PLANNING AMENDMENT

APPLICANT NAME AND ADDRESS MR + MRS BUTLER THE OLD RANCH LOW ROAD HOLBACH HURN Telephone:	AGENT NAME AND ADDRESS BRIAN GILHAM WESTFIELD LODGE LOW LANE HOLBACH Telephone: 01406 424343
SITE ADDRESS DETAILS AS ABOVE	
CURRENT APPLICATION NO: This amendment cannot be considered unless the relevant reference is stated.	H109-0130-24
Building Regulation reference relating to same development (if applicable)

SITE PLAN
1:500

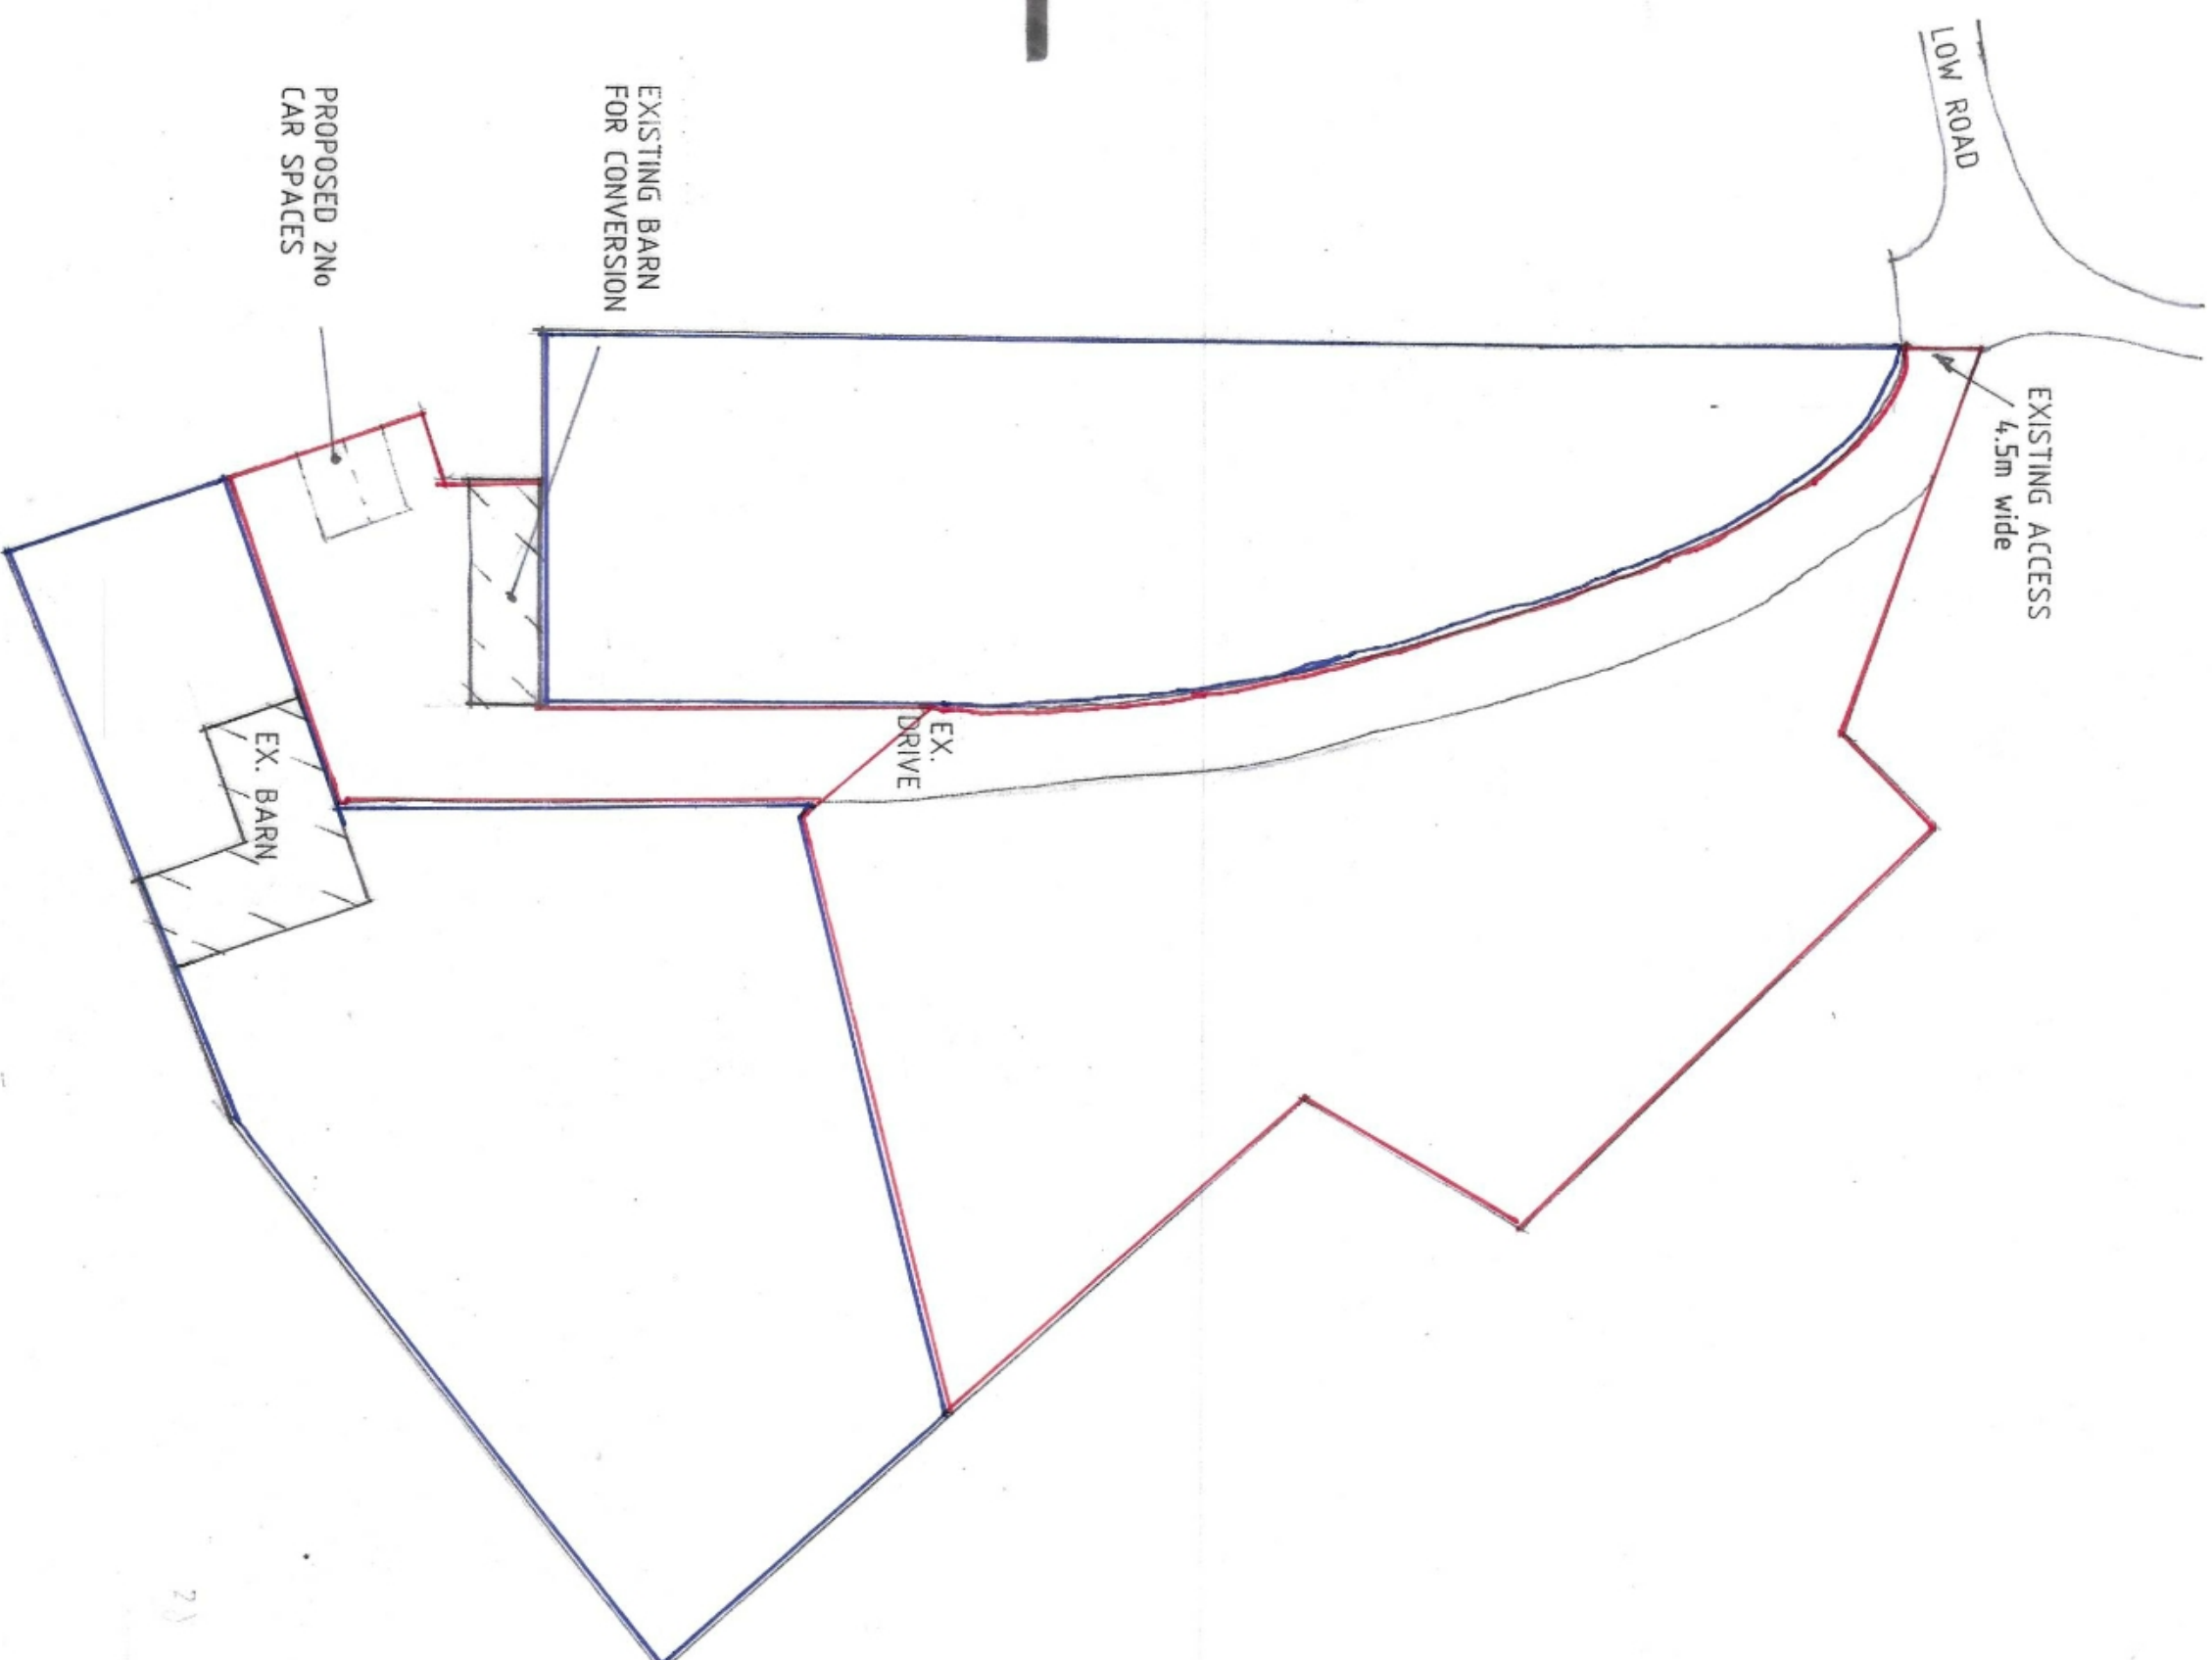
FULL DESCRIPTION OF DEVELOPMENT OF CURRENT APPLICATION THAT THIS AMENDMENT RELATES TO		
State details of amendments proposed. (Give a full detailed list of the changes; and also mark these clearly on the accompanying plans. Only the changes listed here will be considered)	Drawing to show access + site boundary.	
State drawing numbers of the current submission	S024-008/1 S024-008/2	
Has this amendment been requested by the Council? (If so, state Officer dealing with the application)	YES/NO	
Describe any part of the original development which is excluded by virtue of the amendment, and state any alteration to plot numbers		
Has a similar amendment been submitted under Building Regulations? (If so, state Building Control Surveyor dealing with application)	YES/NO
